LEE GAMELSKY ARCHITECTS P.C.

RE: Albuquerque School of Excellence – Remodel
13201 Lomas Blvd NE, Albuquerque, NM 87112

Building Permit NO. 201691547

Final Certificate of Occupancy: Traffic Circulation Layout

A2 HC Parking Sign Detail
3/4" = 1'-0"

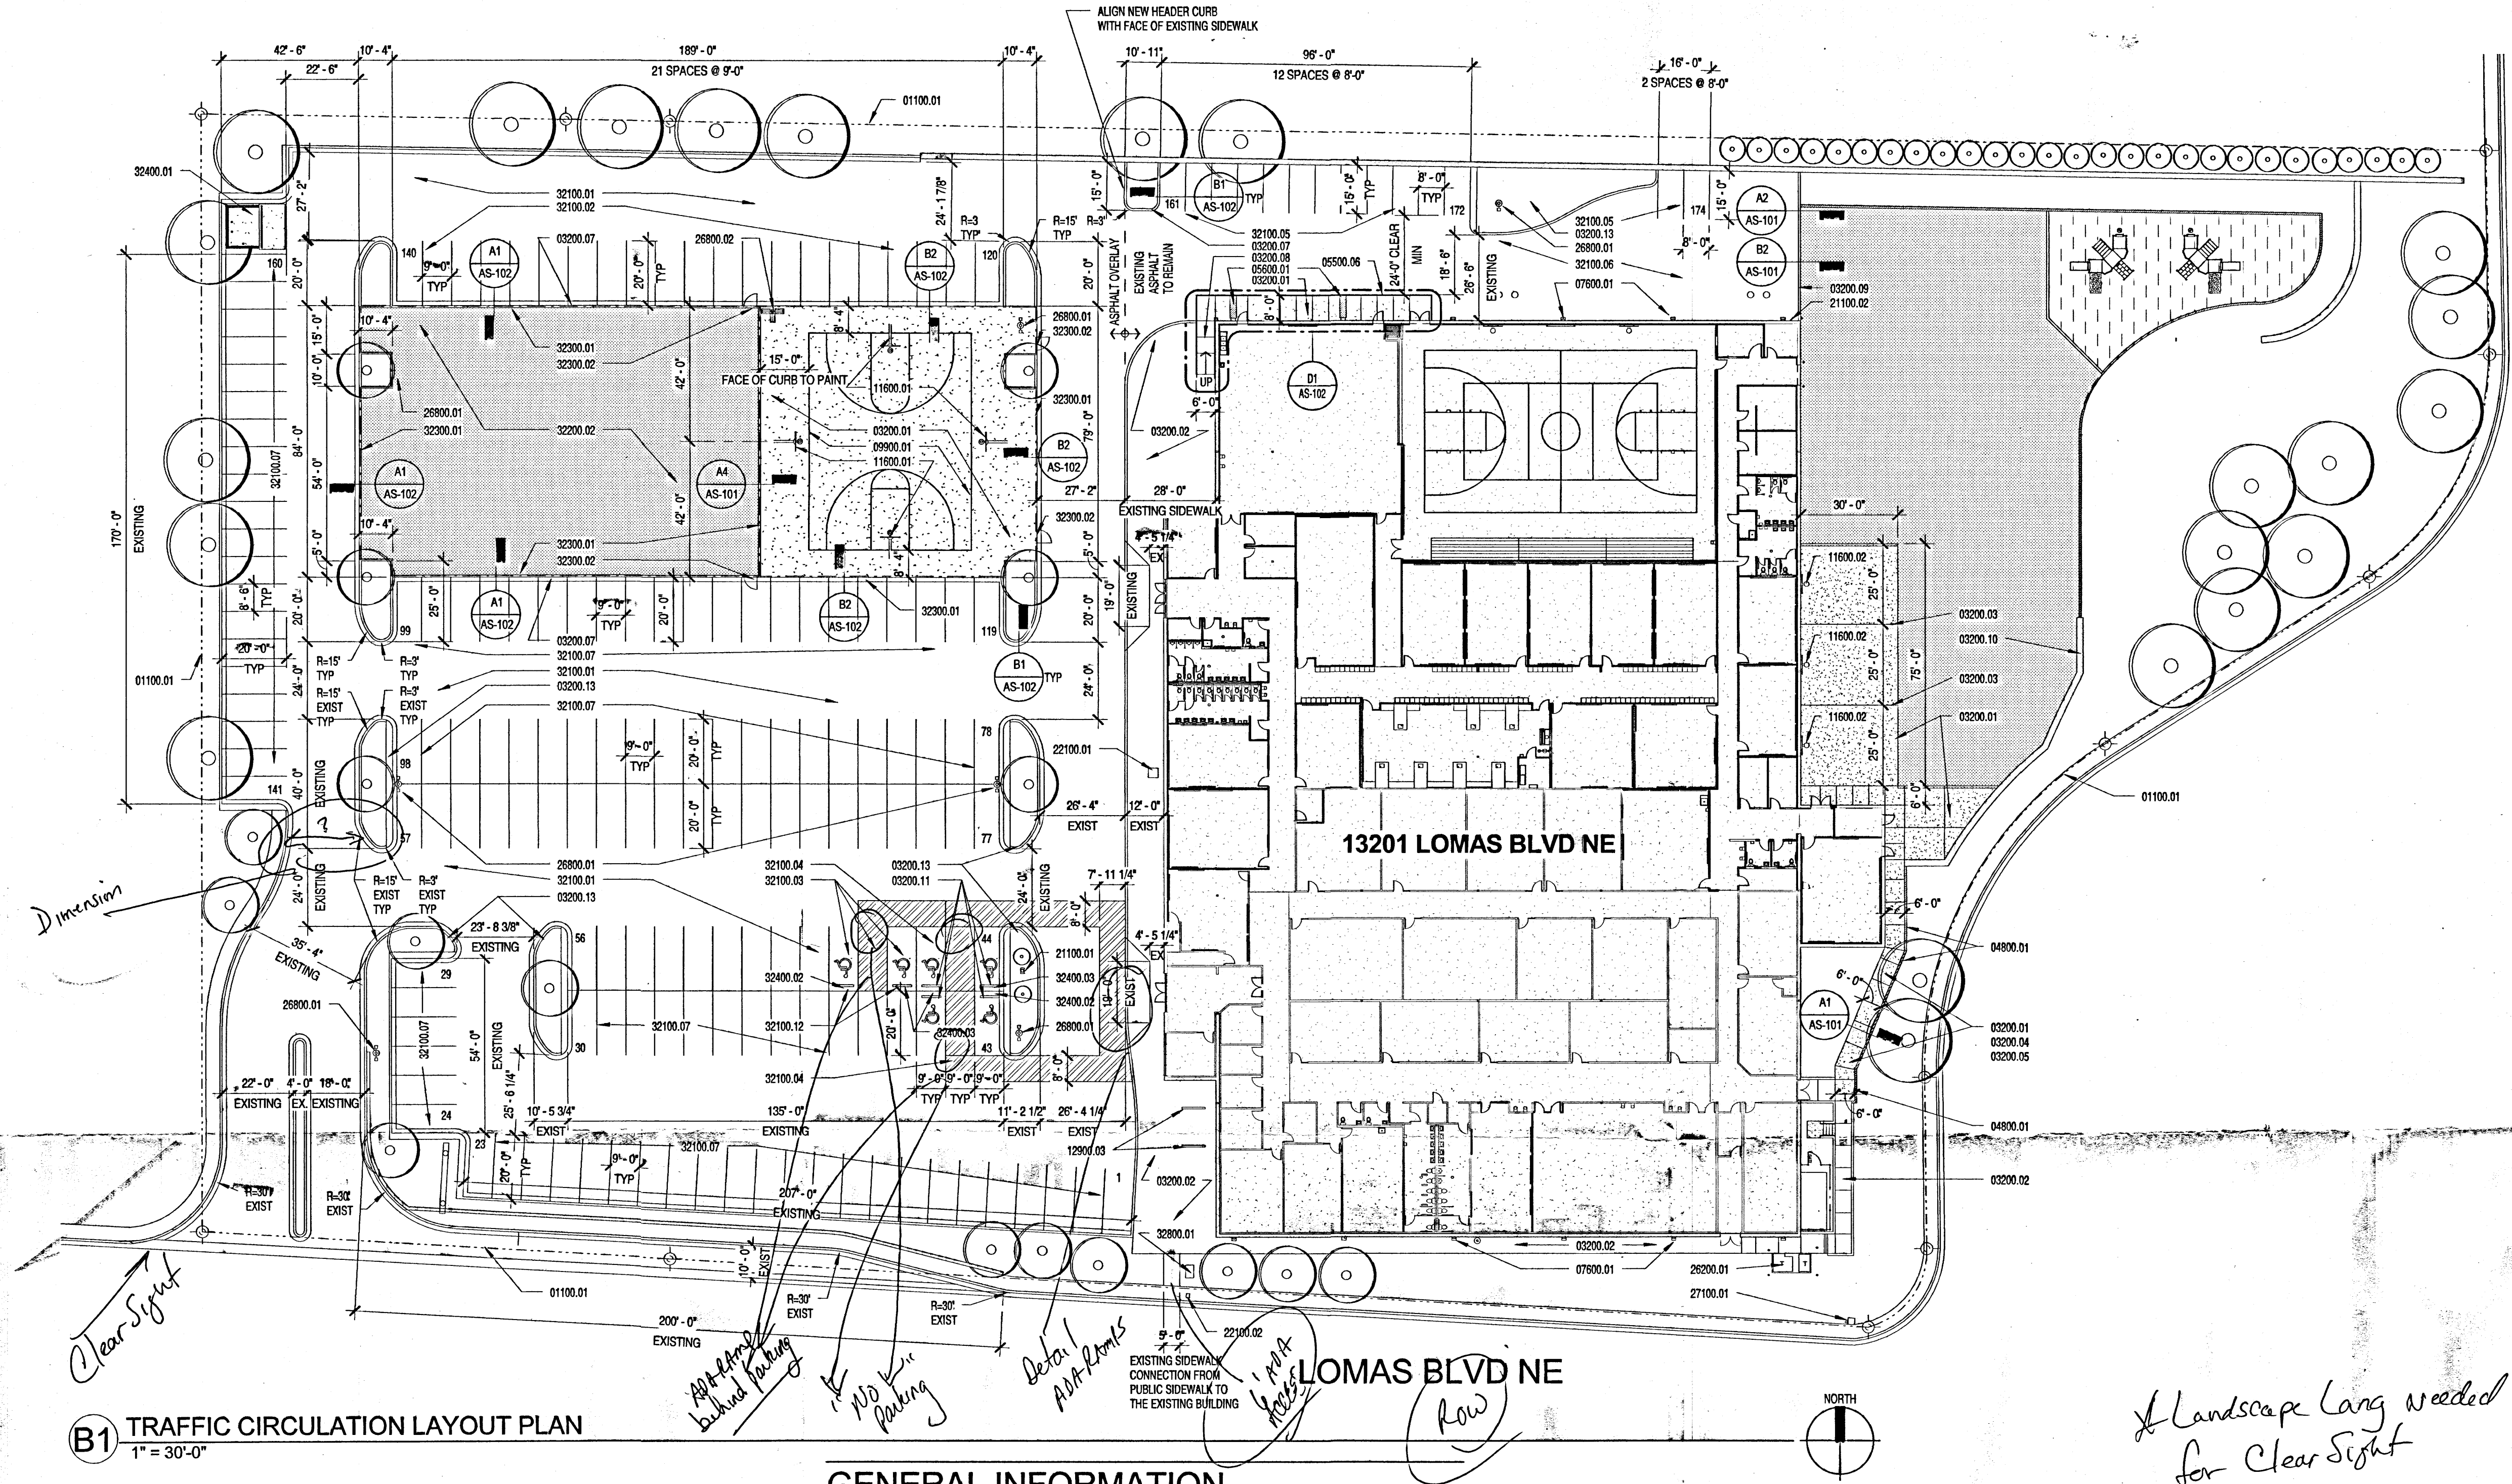
The Owner of the project referenced above has decided to not perform some of the Site Improvements on the project as described and illustrated in the Drawings and TCL. The playground/recreation areas on the west side of the building (within the parking lot) and on the east side of the building will not be constructed at this time. The asphalt areas will remain as is.

These items were redlined in the City and General Contractor's Permit Sets.

Therefore, as suggested by Monica Ortiz, we would like to withdraw the TCL from the Permit Set and not have that work as a condition of approval for a Final Certificate of Occupancy.
